**City of Sydney**

Your Ref: MP 09\_0051 MOD 1

**RE Section 75W - Centre for Obesity, Diabetes and Cardiovascular Disease (CODCD) (MP 09\_0051 MOD 1)**

Drawing
SK-104
LEVEL 2 PLAN

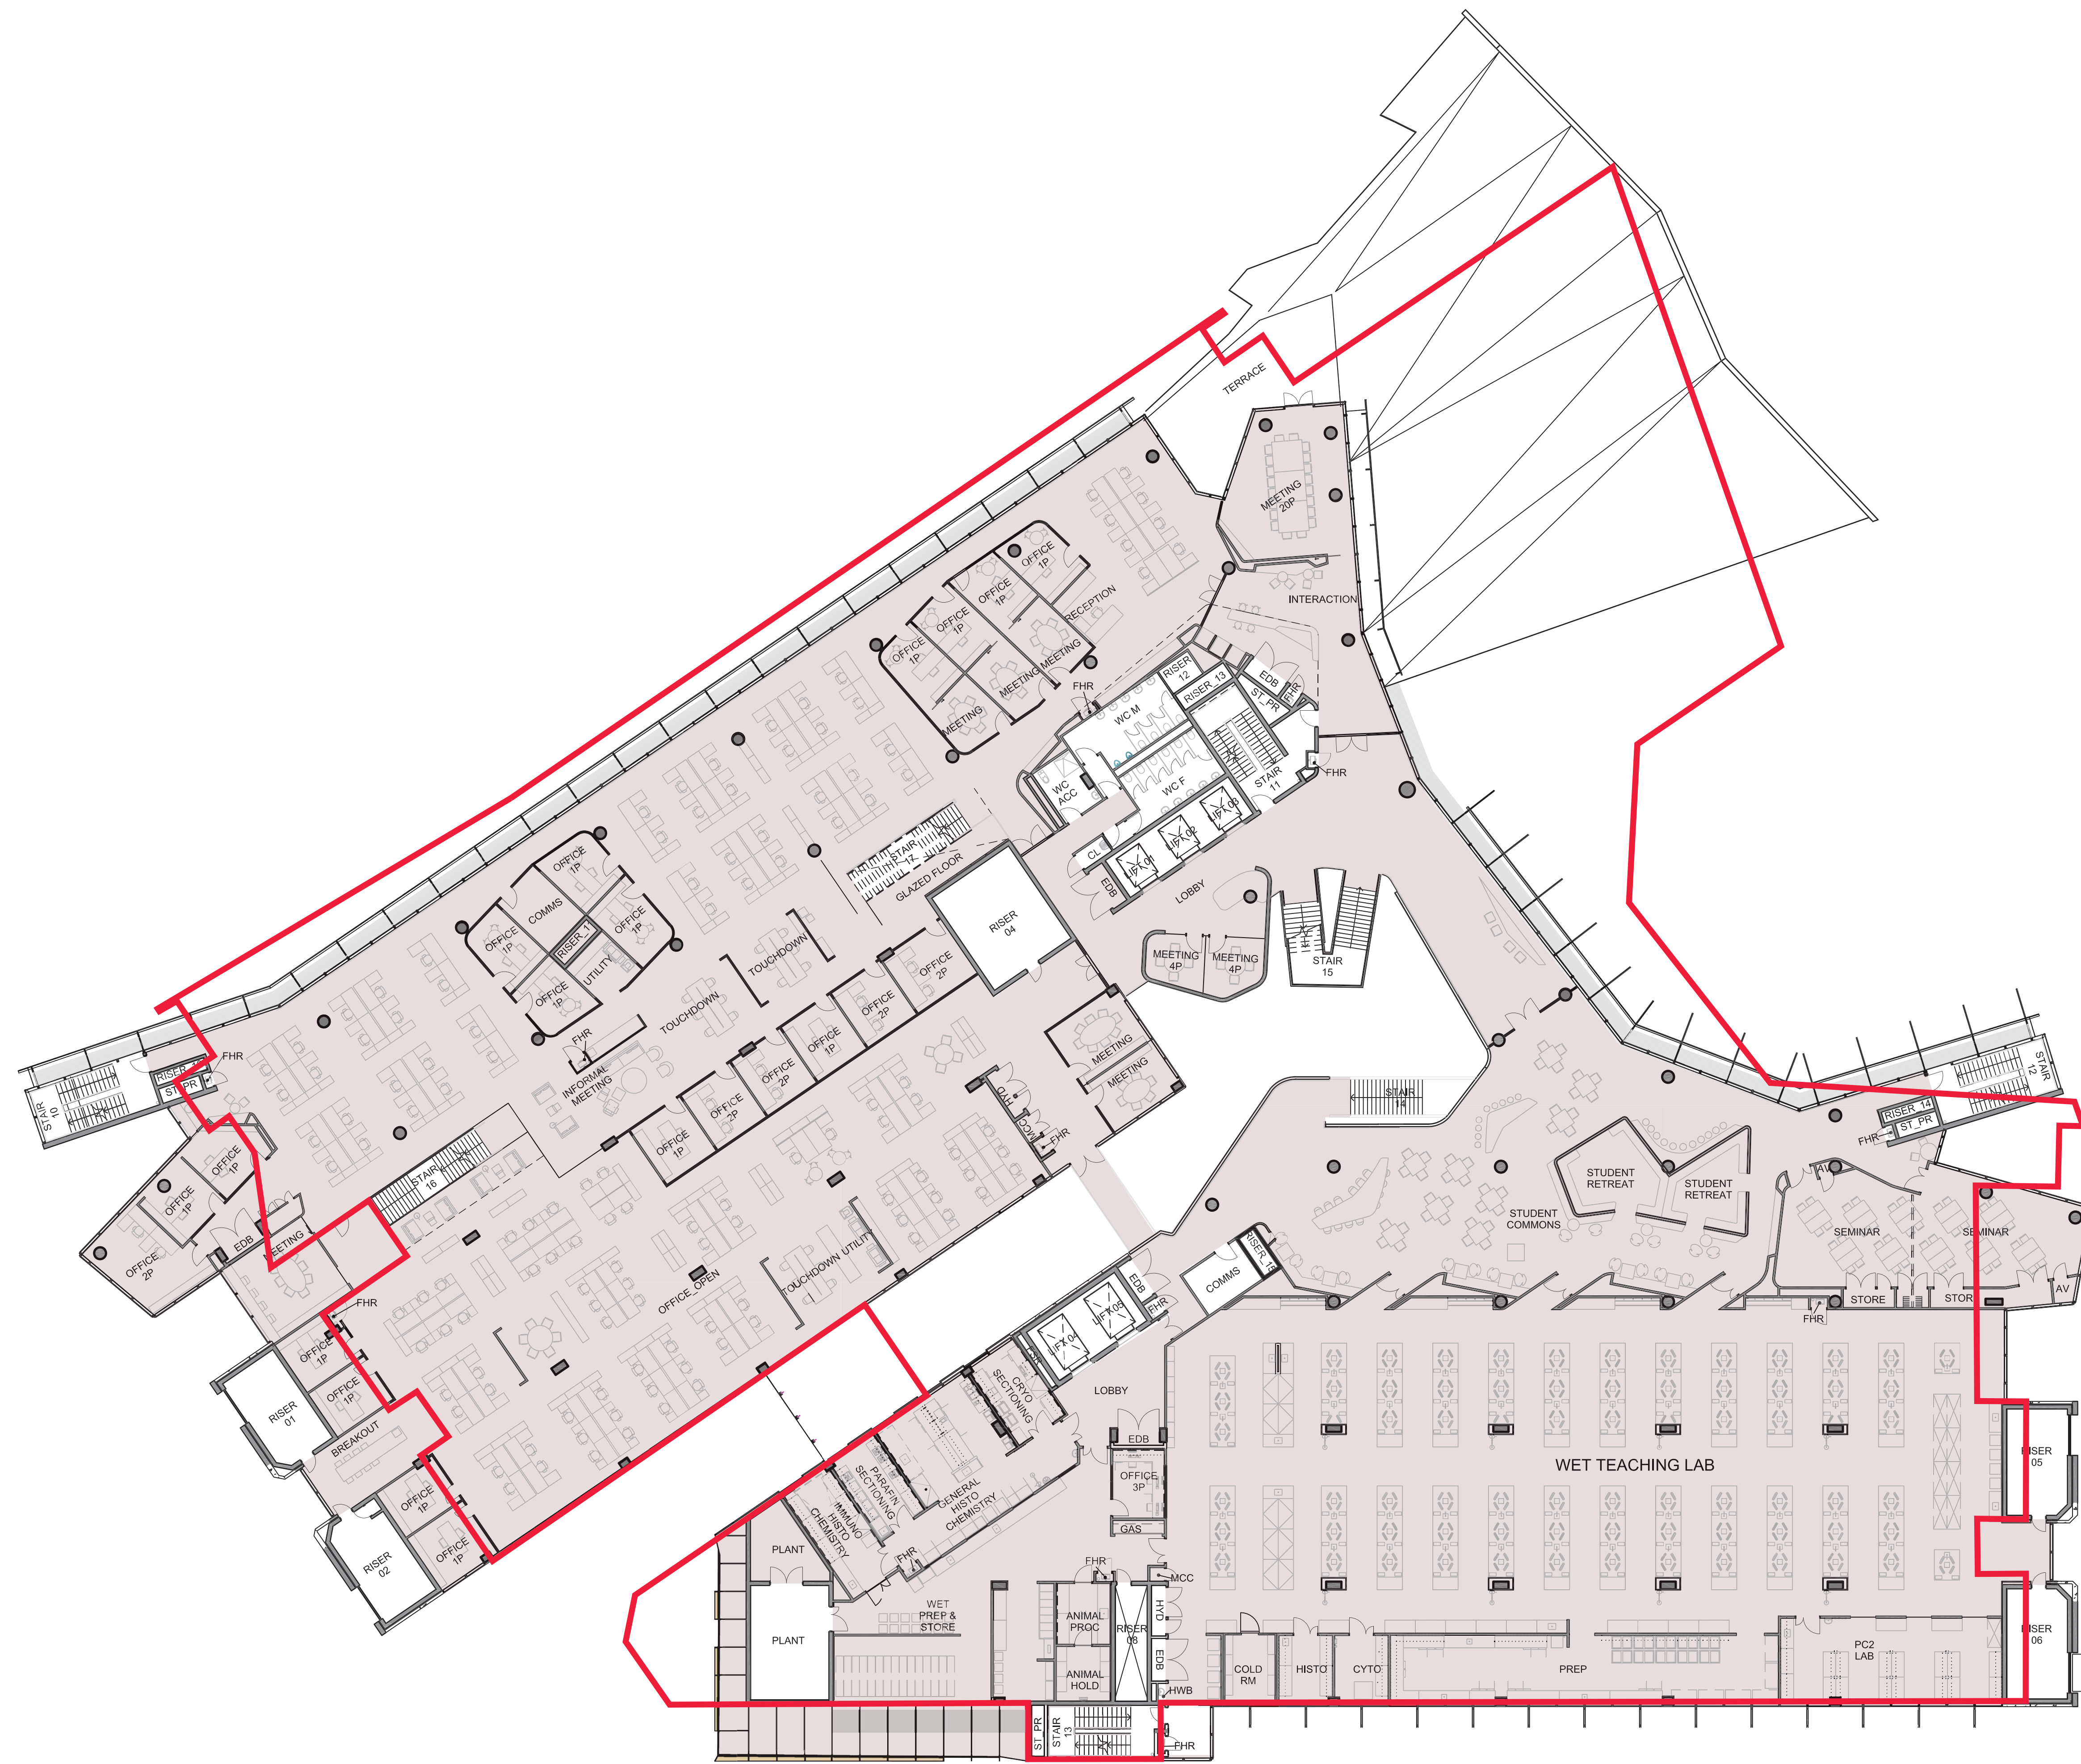
The City supports the reduction in the height of the building but is concerned about other design changes, in particular the increased building footprint towards the western / St John's College boundary and the resultant impacts on St John's College. The issues are discussed below.

The footprint of the CODCD building is proposed to be relocated about 10 metres closer to the western property boundary shared with St John's. The Environmental Assessment does not explain why the building footprint has been extended in this location. The Heritage Impact Statement is silent on the modification. In addition to impacts on St John's, this modification is also considered to impact on the setting of the heritage-listed RPA buildings to the south.

Should any extension of the building footprint be required in order to reduce heritage impacts, it is considered that those extensions should be accommodated at the northern end of the building.
